From: [Haley Mercer](#)
To: [Kelly Bacon \(CD\)](#)
Subject: RE: LP-22-00004 Suncadia Phase 1 Division 14 - Notice of Application
Date: Monday, October 3, 2022 11:02:57 AM

After review of the LP-22-00004 Suncadia Ph 1 Div 14 Preliminary Plat in the internal file I find:

SUNCADIA PHASE 1 DIVISION 14
PRELIMINARY PLAT

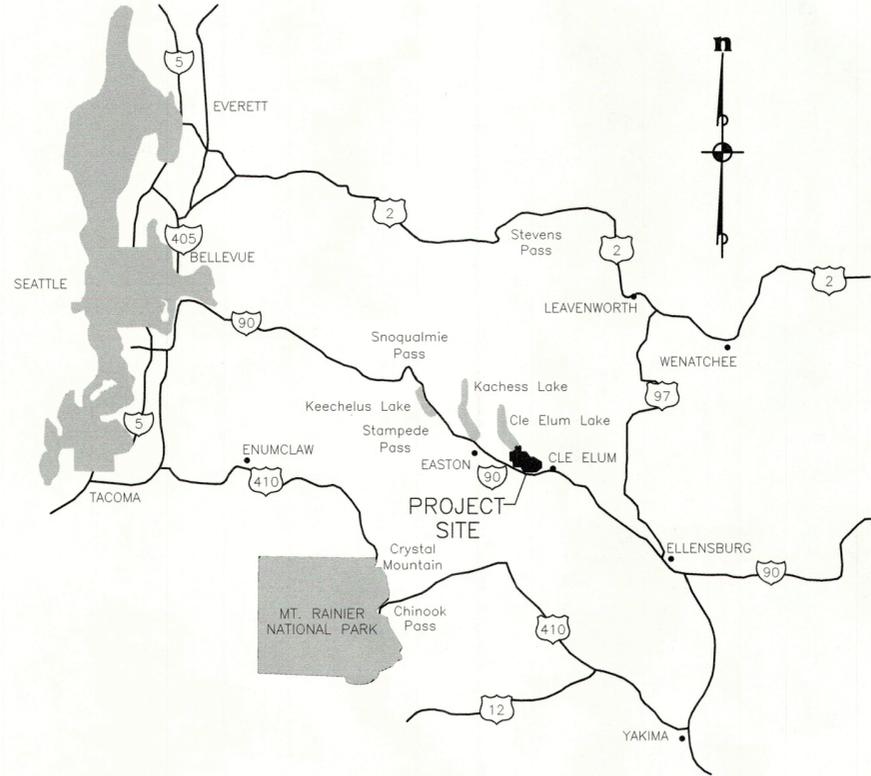
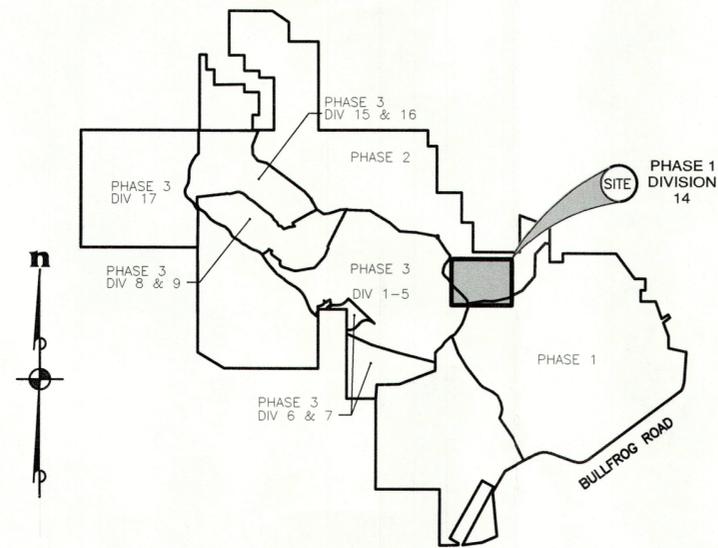
- Parcels 953915 and 953917 are not listed on the plat.
- Suncadia Community Council missing from plat ownership list.
- Did not notice a dedication page nor department signature pages.
- Original legal descriptions on face of plat have errors:
 - Tract OS-3, page is incorrect, should be 78 not 79.
 - Tract A, I'd think it should also include the portion reference for Tract Z-5.
